Reference: 12.060r06v02

**Re: Orica Southlands Lot 9 (SSD-9691) – Proposed Warehouse Development
28 McPherson Street, Banksmeadow
Response to Road Safety Audit**

Concept design road safety audit

TRAFFIX Response to RSA

Drawing: **SITE PLAN - OPTION 6**
NO ACCESS VIA NANT STREET
Scale: 1: 1500 @A3 Project No: 180101 Drawing No: SK - A 106 Issue: P4
Drawn: AA Date: Jan 2018

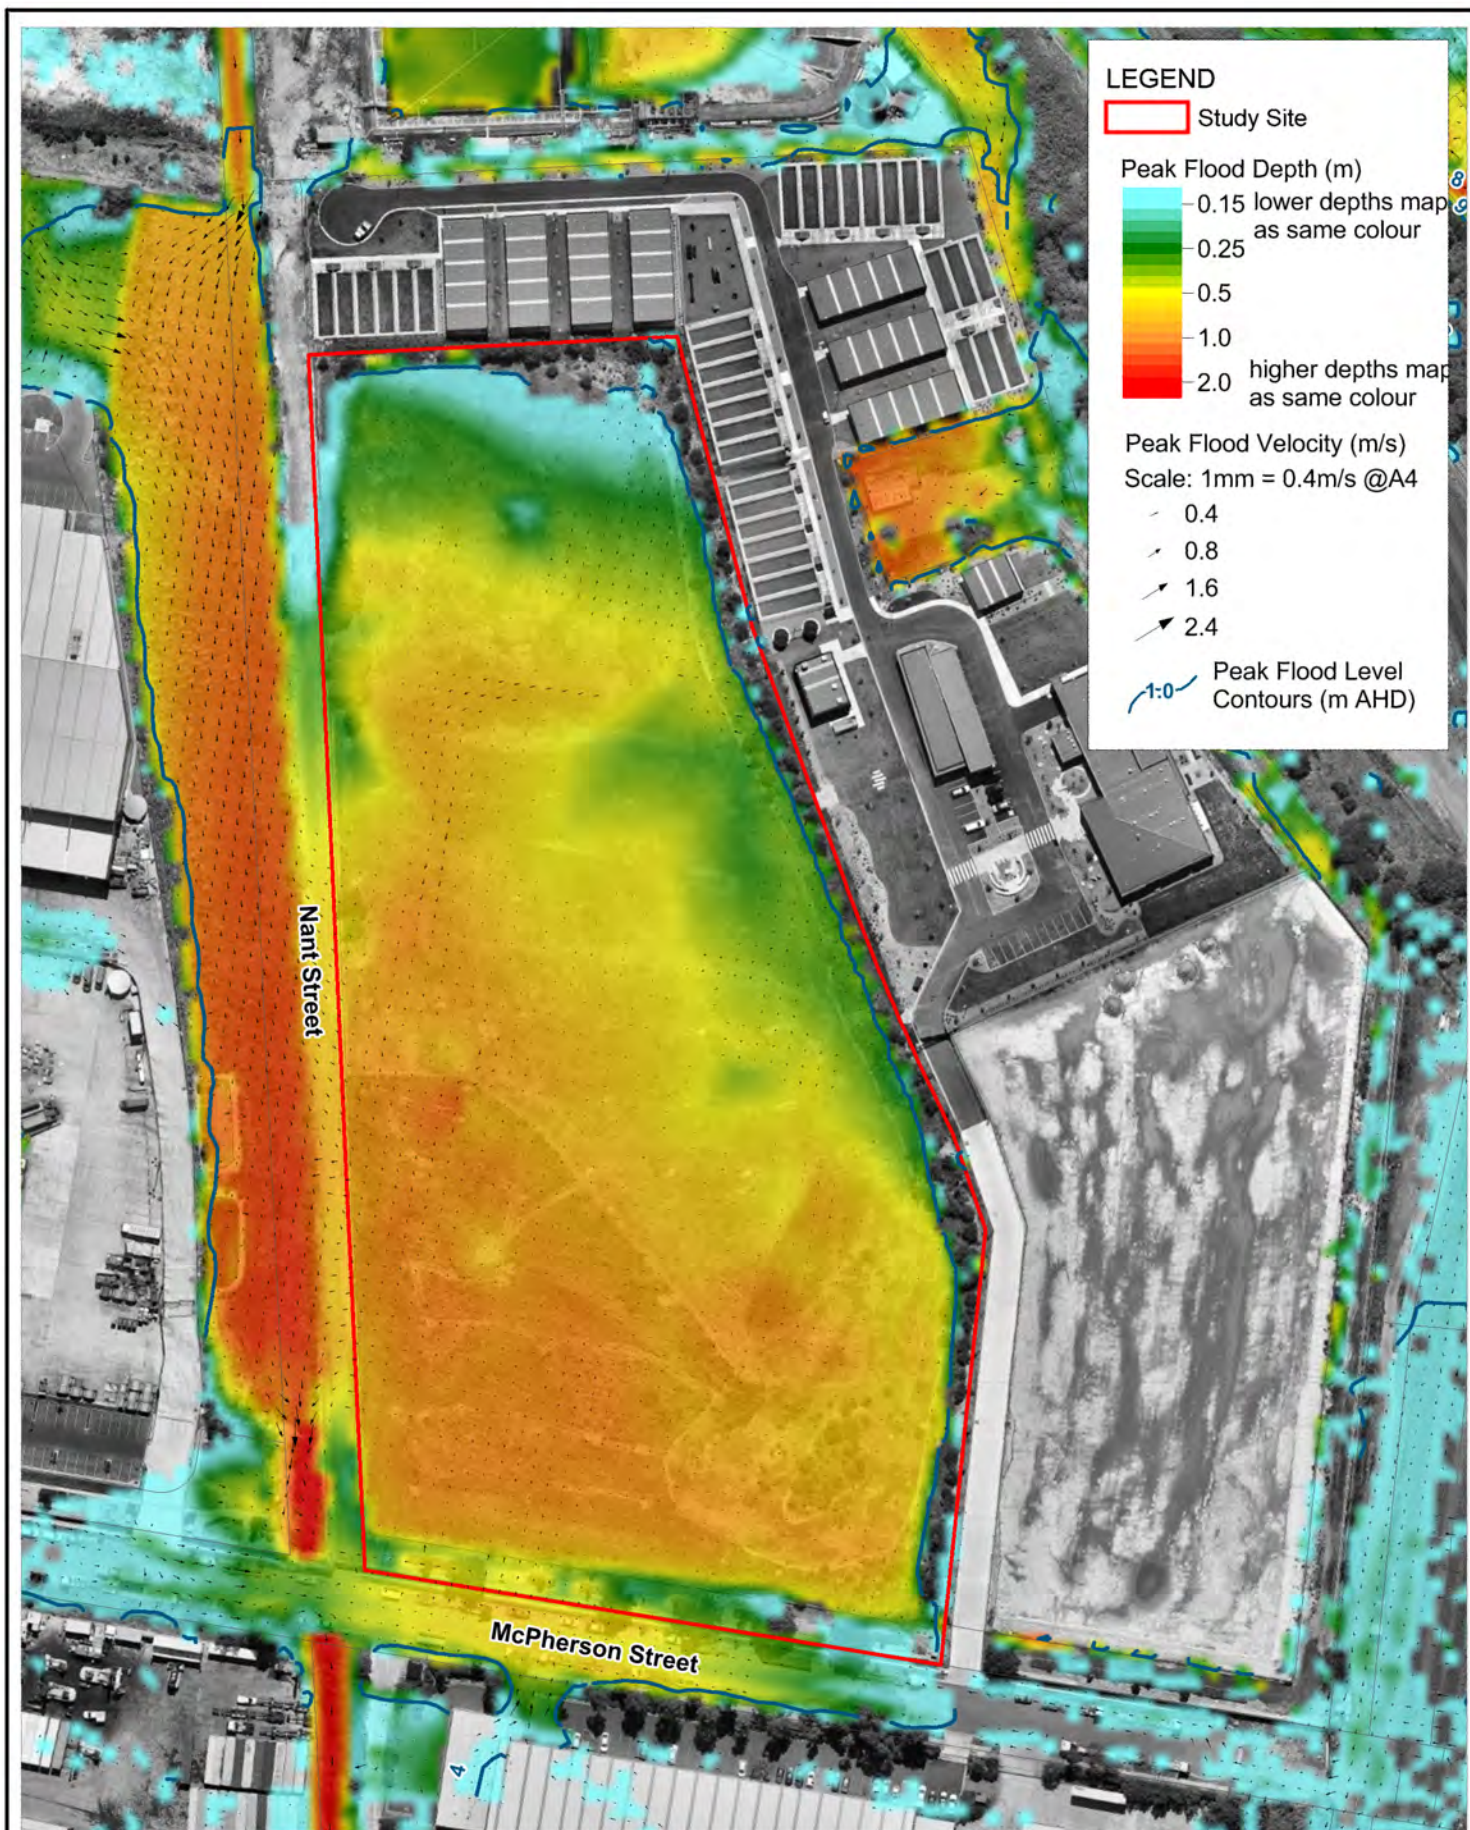
Ref	Location	Road safety audit findings	Priority
1a	Egress movements from the property driveway.	<p>The proposal includes a driveway which will stem off the northern side of McPherson Street. The design indicates that there would be landscaped areas on the northern verge of McPherson Street either side of the driveway. However, the vegetation type was not specified. There is a risk that if tall shrubs or trees are planted, these may obstruct the following sightlines to the driveway.</p> <ul style="list-style-type: none"> ▪ The <i>stopping sight distance</i> (SSD) from eastbound drivers on McPherson Street to the driveway. This is the sight distance needed for eastbound drivers to detect a potential hazard emerging from the driveway, to react and then brake to a full stop. Figure 3.2 of AS2890.1 indicates that for a 50km/h design speed, an SSD of 45m would be required. The SSD by westbound drivers (ie. by drivers on McPherson Street approaching the driveway from the east) is less critical since (i) this traffic stream would be further (laterally offset) from the northern kerblines and driveway of the road and hence less likely to be obstructed by landscaping and (ii) there would be substantially less traffic approaching the site from this side since it is a terminating road with a cul-de-sac. ▪ The <i>minimum gap sight distance</i> (MGSD) from egressing drivers in the driveway to the east and west. These are the sight lines needed by an egressing driver to view approaching traffic and detect and select safe gaps to turn out of the driveway. Figure 3.2 of AS2890.1 adopts a critical gap time of 5 seconds which equates to an MGSD of 69m at a 50km/h design speed. <p>These risks would be appropriately mitigated by keeping the landscaping in the northern verge, particularly along the sight lines discussed above, to low-height species only. This includes any support frames used during the establishment period.</p> <p><i>NB. The audit team notes the potentially sight-obstructing impacts due to parked cars, trucks and trailers on the northern kerblines. However, this was not raised as a formal audit finding since this is common practice along McPherson Street, and any such parked vehicles would also tend to have a speed-limiting effect compared with vacant kerblines. As such, whilst parked vehicles/ trailers may restrict sight lines, they also reduce demand for sightlines by virtue of the lowered traffic speeds.</i></p>  <p>Above: The egressing driver will need clear MGSD sight lines to detect and select safe gaps to enter McPherson Street. The red lines are used to illustrate the potential impact to the MGSD sight line if constrained by (i) tall vegetation planted in area X and (ii) if the trees to the west of the driveway are tall and sight-obstructing.</p>	High

Ref	Location	Road safety audit findings	Priority
1b	Egress movements from the property driveway.	<p>Further to item 1a, the egressing driver will also need to be aware of any pedestrians that may suddenly move into a crash conflict space. For example, a pedestrian at the Nant Street right-of way (labelled "ped" and circled in red) may emerge into the space of the egressing vehicle (blue rectangle) with risks of <i>vehicle-pedestrian</i> crashes. This is especially if the pedestrian is obscured by tall landscaping or boundary fencing. With respects to the latter, the right-hand image shows the extremely limited "see-through" visibility through this palisade fence used on the adjacent property to the west. The combined effect of the closely spaced balusters and the acute viewing angle towards and "through" the fence means that drivers would not have clear visibility to the area behind the fence. The same risk could arise with egressing drivers and pedestrians emerging from the sides of the driveway.</p> <p>Similarly, egressing drivers will need clear sight lines to any pedestrians at point "Y". This means this area should also be kept free of tall and sight-obstructing vegetation and the impact of any boundary fencing should also be considered.</p> <div data-bbox="521 501 1731 1011"> </div> <p>Left: Extract from the design showing the potential risks of vehicle-pedestrian crash risks if pedestrians emerge into a crash conflict space with the egressing driver without any warning or advanced expectation. Right: The palisade fences used along most properties along McPherson Street have limited "see-through" visibility due to the closely spaced balusters and the acute viewing angle.</p>	High

Ref	Location	Road safety audit findings	Priority
3	Pedestrian access and egress from the site.	<p>The design indicates that a 1.8m wide walkway will be provided on the western side of the driveway for pedestrian access (shaded in yellow in image below). However, the audit team notes the following general issues with respects to pedestrian safety:</p> <ul style="list-style-type: none"> As the office to Warehouse 1 is on the eastern (right-hand) side of the driveway, any pedestrian movements to this building from the street are more likely to be across the middle of the driveway as shown by the red line. This is due to the substantially shorter walking distance. This could create direct <i>vehicle-pedestrian</i> crash conflicts involving vehicles on the driveway and from the car park access aisle. The plans state that a 1800mm wide zone will be provided along the yellow line for a “path plus barriers”. It is not clear from the designs whether the barrier will be on the western side of the walkway or on its eastern side such that it forms a separation between the walkway and the driveway. Whilst the latter would ensure better protection for pedestrians against driveway traffic movements, it would only service pedestrian access needs to Warehouse 2. There does not appear to be any gaps in the barrier to access Warehouse 1. This would also force pedestrians to walk along the driveway if heading to Warehouse 1. <p>Pedestrian movements from the street to the buildings is conceivable with any parking of vehicles on the street or if workers leave the site for lunch and return etc.</p>  <p><i>Left: Pedestrian movements from the street to the building of Warehouse 1 via the driveway would be an attractive walk path due to the shorter distance.</i></p>	Medium

Ref	Location	Road safety audit findings	Priority
4a	The impact of Nant Street on safe operations of the property driveway.	<p>At the time of the inspection, Nant Street was not a publicly accessible road. In fact, it was gated and access-egress appeared to be restricted for authorised users only (see left-hand image). Notwithstanding this, the audit team recognises that this appears to be a formal right-of-way which may evolve into a publicly accessible road.</p> <p>The long-term function and access to Nant Street would strongly govern the safe performance of the proposed driveway at 28 McPherson Street. If Nant Street remains a restricted access road, then its impacts on the proposed property driveway would be relatively benign. However, if this side road attracts more frequent use, there could be significant impacts to the safe operations of the subject driveway. Some examples include:</p> <ul style="list-style-type: none"> ▪ If an egressing driver (blue vehicle in right-hand image) sees an eastbound vehicle (red) approaching with its left-turn indicator light activated, the driver of the blue car may falsely believe that the red vehicle will turn left into Nant Street. If this is actually an intended left-turn into the subject driveway, there could be more direct interaction between the two vehicles with corresponding crash risks. ▪ A similar risk would also apply to outbound drivers from Nant Street. If they see an eastbound vehicle with left-turn indicator lights activated, they may falsely believe that the vehicle will turn into Nant Street. They may therefore attempt a right-turn out of the site at the same time. However, if the eastbound left-turning vehicle is in fact heading to the subject driveway at 28 McPherson Street, this could result in a <i>cross-traffic</i> crash between the two vehicles. <p>Continued over the page...</p> <div style="display: flex; justify-content: space-around;">   </div> <p>Left: During the site inspection, Nant Street appeared to be a right-of-way for vehicular traffic. However, this was closed off to public traffic and gated. The long-term function and access of this road was not known. Right: A situation where an egressing driver from the subject driveway sees an eastbound vehicle with its left-turn indicator lights activated and falsely believes that this is an intended left-turn to Nant Street.</p>	Low (much of this is uncertain based on the unknown long-term function of Nant Street)

Ref	Location	Road safety audit findings	Priority
4b	The impact of Nant Street on safe operations of the property driveway.	<p>Continued from previous page...</p> <ul style="list-style-type: none"> ▪ If Nant Street is frequently used as an access-egress point, there could also be a conflict between coinciding left-turns from this right-of-way (vehicle A) and the subject driveway (vehicle B). This is particularly because both vehicles would tend to move into McPherson Street under similar gap-opportunities. That is, if there are coinciding gaps in the eastbound and westbound traffic directions of McPherson Street and both vehicles A and B decide to make a right-turn at the same time, this could create a crash conflict between the two vehicles. ▪ Further to the previous point there is also a cross over crash conflict if vehicle A decides to turn right and vehicle B decides to turn left. However, this is less critical since an egressing left-turn movement would be relatively rare due to the terminating nature of McPherson Street and its cul-de-sac to the east.  <p>The diagram illustrates a road intersection. A horizontal road labeled 'ER BRIDGE' runs across the bottom. A vertical road, 'Nant Street', intersects it from the top. A driveway, labeled '10m', branches off from the vertical road to the right. Vehicle A is shown on the vertical road, with a blue arrow indicating a left-turn movement into the horizontal road. Vehicle B is shown on the driveway, with a red arrow indicating a right-turn movement into the horizontal road. The text 'Left: The risk of coinciding left-turns if Nant Street becomes a frequently used side road.' is positioned to the right of the diagram.</p>	Low (much of this is uncertain based on the unknown long-term function of Nant Street)

Audit Reference Number(s)	Location	TRAFFIX Response
Item 1a <i>High Priority</i>	Egress movements from the property driveway	<p>TRAFFIX has reviewed the audit team findings and considers the potential risks associated with stopping sight distance (SSD) and minimum gap sight distance (MGSD) at the proposed vehicular access to be minimal, noting the following key aspects:</p> <ul style="list-style-type: none"> • Orica will retain ownership of the front 10 metres of the site, which contains critical ground water infrastructure. The 10 metre strip currently contains landscape, with existing GTP infrastructure unable to permit additional planting. Therefore, the proposal does not include any additional planting or landscaping that will obstruct SSD/MGSD areas; • Existing palisade fencing to be retained to protect GTP infrastructure; and • Any obstructions that can potentially obstruct SSD/MGSD areas are to have a maximum height of 600mm. <p>In light of the above, the SSD and MGSD areas within the site will effectively remain clear, thereby mitigating any potential risks associated with sight distance visibility for egressing drivers of the development.</p>

Item 1b <i>High Priority</i>	Egress movements from the property driveway	<p>The proposed vehicular access is provided 2.5m x 2.0m visual sight splays for egressing drivers, as required under AS2890.1 (2004) Figure 3.3. These visual sight splays are proposed to be clear of any obstructions to visibility, noting the following exceptions:</p> <ul style="list-style-type: none"> • Palisade fencing or any other fencing that will not obstruct an egressing driver's visibility. It should be noted that palisade fencing is widely utilised at the vehicle access for several warehouse developments to enable egressing drivers to identify potential pedestrians at the vehicle access; and • All obstructions (excluding palisade fencing) and landscaping are to have a maximum height of 600mm, which is consistent with various councils. <p>In addition to the above, it is noted that Nant Street is primarily utilised as the main access for the Qenos Tank Farm, located to the immediate north of the site on an intermittent basis only. The unformed Nant Street sits within the flood storage area for the local area, which would require considerable filling in order to transform Nant Street into a usable heavily trafficked road. Accordingly, Nant Street is highly unlikely to become a more trafficable road and does not accommodate general vehicle or pedestrian traffic, with a rarely opened gate restricting public access to the road. As such, pedestrian activity from Nant Street is envisaged to be considerably low (if any).</p> <p>In summary, the above arrangements are considered appropriate to satisfy the requirements of AS2890.1 (2004), therefore considered acceptable.</p>

Item 3 <i>Medium Priority</i>	Pedestrian access and egress from the site	<p>The development proposes a 1.3 metre wide pedestrian footpath along the western boundary of the development for pedestrian access from McPherson Street. As such, pedestrians are provided increased separation and protection from vehicle circulation movements, noting that the development can also provide an additional pedestrian access on the eastern side of the driveway for access to Office 1, which can be incorporated within the detailed design plans during the construction certificate stage.</p> <p>These arrangements are considered acceptable and will ensure all pedestrians are provided separated access to both offices/warehouses.</p>

Audit Reference Number(s)	Location	TRAFFIX Response
Item 4a and 4b <i>Low (much of this is uncertain based on the unknown long-term function of Nant Street)</i>	The impact of Nant Street on safe operations of the property driveway	<p>As previously mentioned, Nant Street is primarily utilised as the main access for the Qenos Tank Farm, located to the immediate north of the site on an intermittent basis only. As such, this road does not accommodate general traffic, with a rarely opened gate restricting public access to the road. This is emphasised with traffic count surveys that were conducted in October 2018, which identified no vehicle movements from Nant Street during the morning and evening peak periods.</p> <p>In addition to the above, Nant Street is acknowledged to be owned by Bayside Council, however, the road itself is considered to be within a flood prone area, hence not considered appropriate to accommodate public traffic. Furthermore, in order to make the road function as a public road it would be required to be filled and its levels increased to meet flood requirements. This in turn would have unacceptable impacts on the surrounding flood levels. For this reason, Nant Street is envisaged to remain as an unformed road that does not accommodate general traffic, hence mitigating any potential conflicts at the proposed access.</p>
